Response to Planning Application

From: Arun District Council Greenspace

Application ref: BN/1/21/DOC

Location: Land At Angels Nursery Yapton Road Barnham PO22 0AY

Community Hall

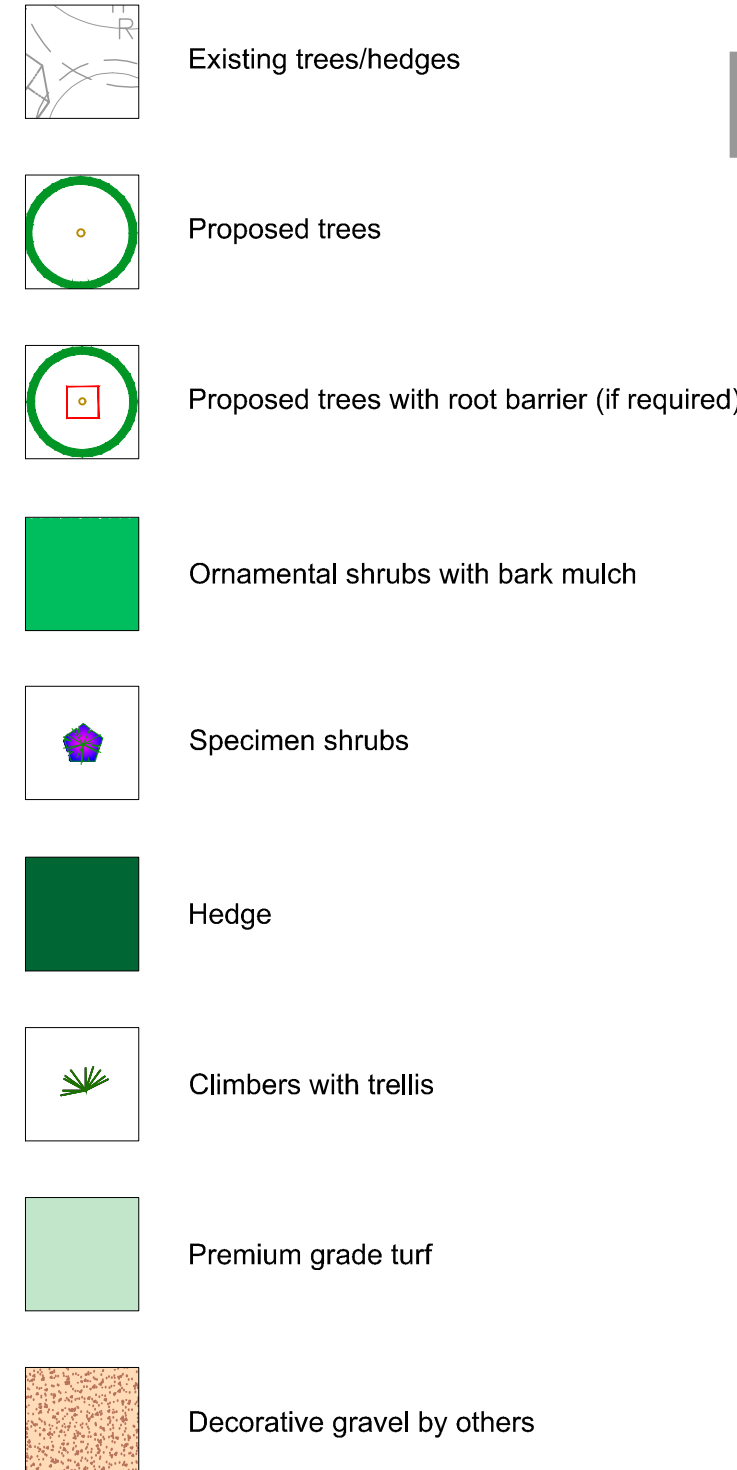
This response is following submission of the Enhanced Proposals Sheets 17890 01/02 Rev B Soft Landscaping and Hard Sheets 1&2 relating to conditions under BN/84/20/PL. I confirm that the information submitted relating to detailed on plot and adjacent areas does propose a scheme which is both functional and ornamental in its design which will form a pleasing scheme for this setting. The proposals will allow for the softening of this development with the use of ornamentals with the addition of further impact specimens alongside the hard landscape features within this space.
